Arun District Council
Arun Civic Centre
Maltravers Road
Littlehampton
West Sussex BN17 5LF
Planning & Building Control General
Enquiries

**The Town and Country Planning Act 1990 (as amended)
Town and Country Planning Development Management Procedure Order 2010 (as amended)**

**Replacement dwelling
44 Broadmark Lane Rustington**

DRW NO 3a SCALE 1/50
 PROPOSED ROOF PLAN

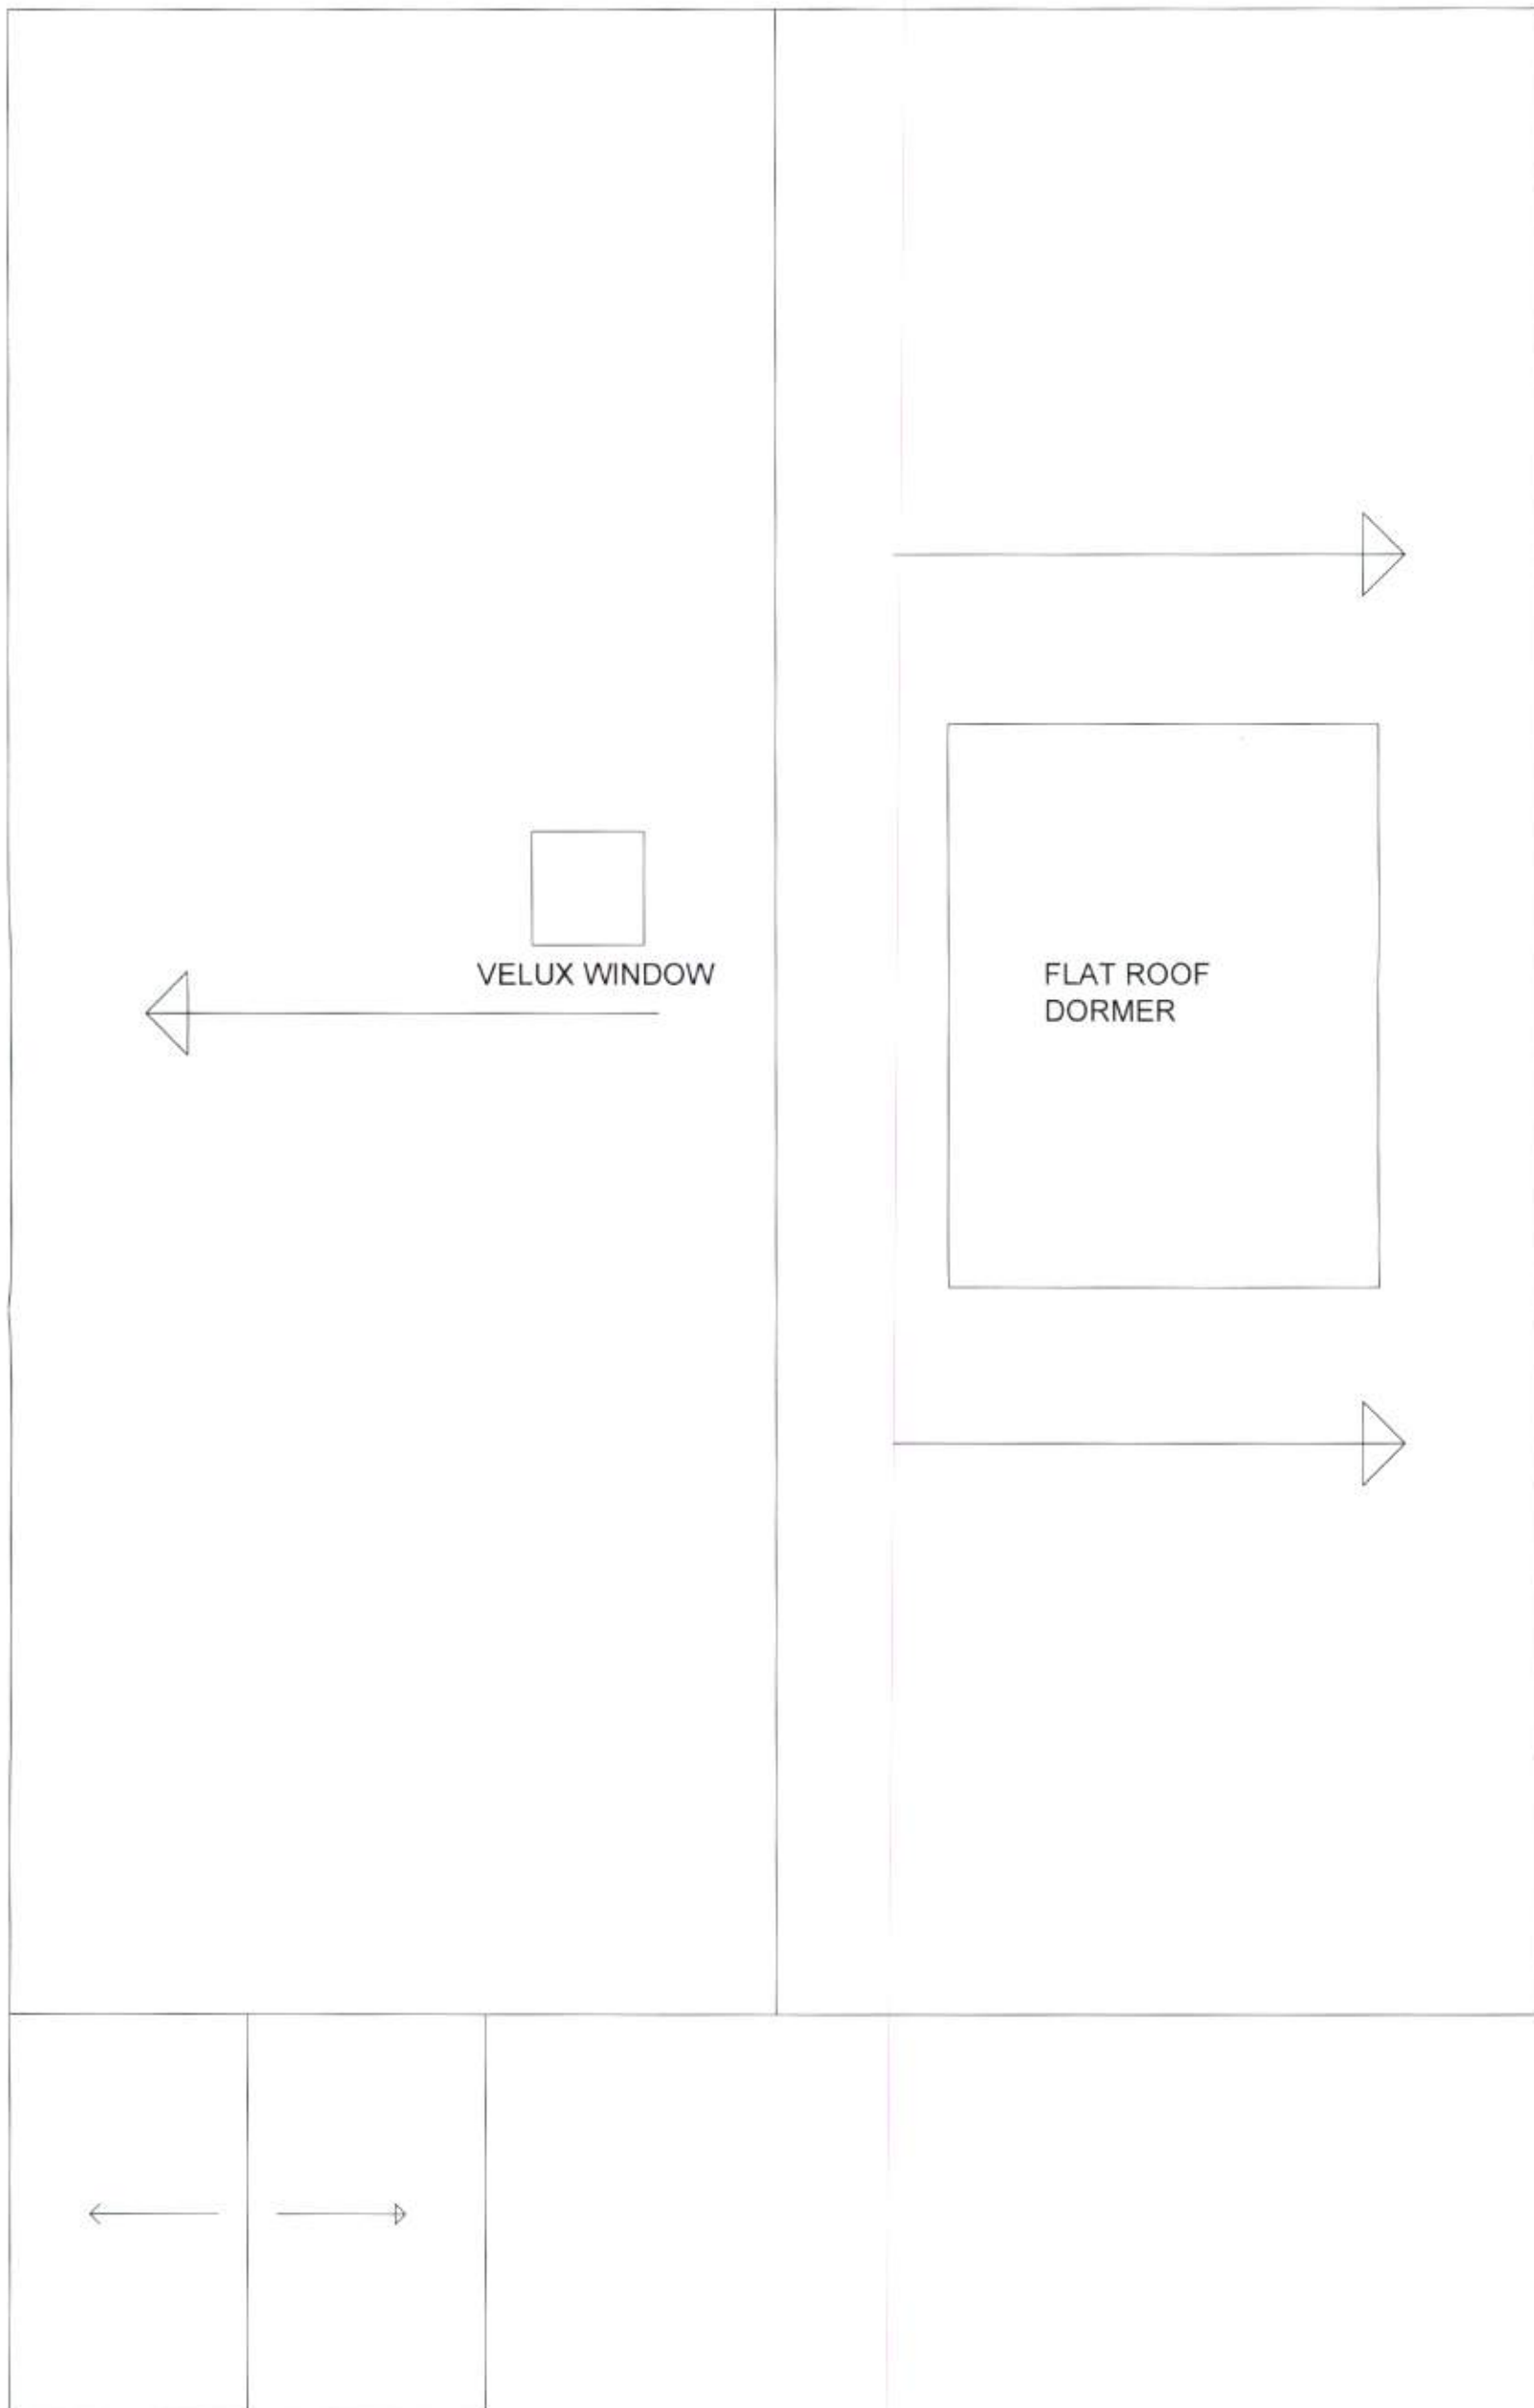
Please submit 1 electronic or 3 paper copies of a revised proposed roof plan to show the dormer section.
